SFRM REPORT ON BEAM OR COLUMN
ASTM E605/E736

Project Name: Luminato Condominiums
Project Number: 16-0910
Client: Luminato Condominiums, LLC
SFRM Supplier: Grace Construction Products
SFRM Material: Monokote Z-106/HY
SFRM Installer: New England Fireproofing, Inc.
Installation Date: Week of 12/26/16

1 SECOND FLOOR FRAMING PLAN  
3/16" = 1'-0"

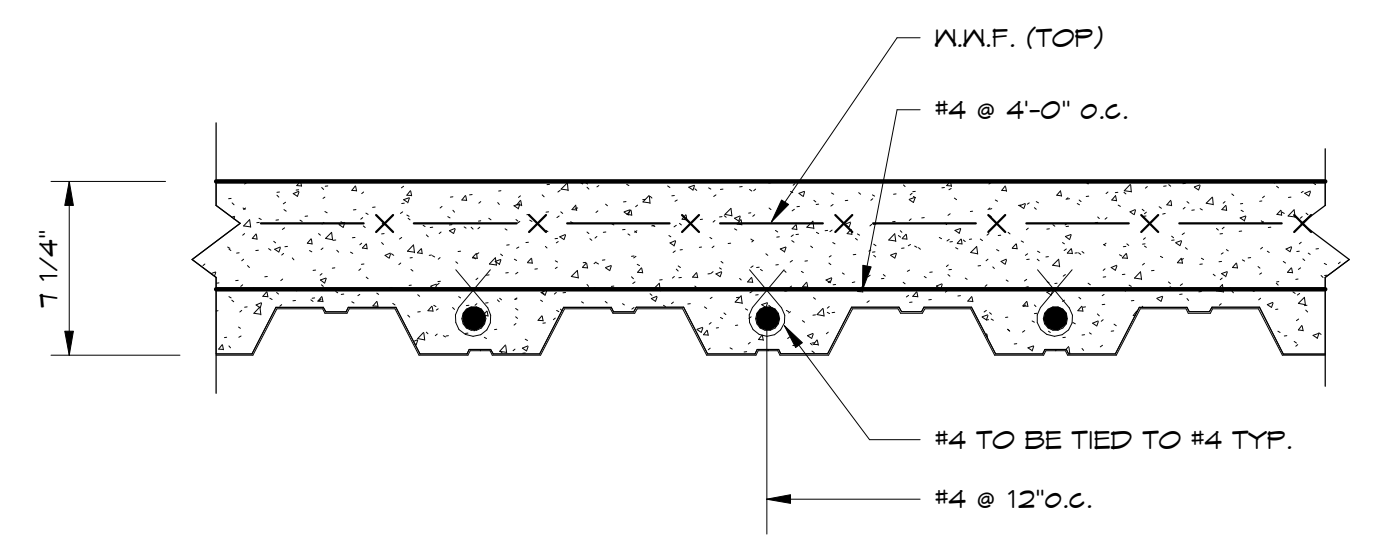
Location	Member Type	Required Thickness	1	2	3	4	Average Thickness
S102, Brace A	HSS 6x6x1/4	2.688	2.813	3.500	2.500	3.250	2.813
			2.875	3.063	2.563	3.000	
S102, Brace C	HSS 6x6x1/4	2.688	3.000	2.688	1.875	3.000	2.610
			3.063	2.750	1.813	4.000

Comments: "Outside" face of both HSS sections at Brace C need additional thickness to satisfy project requirements.
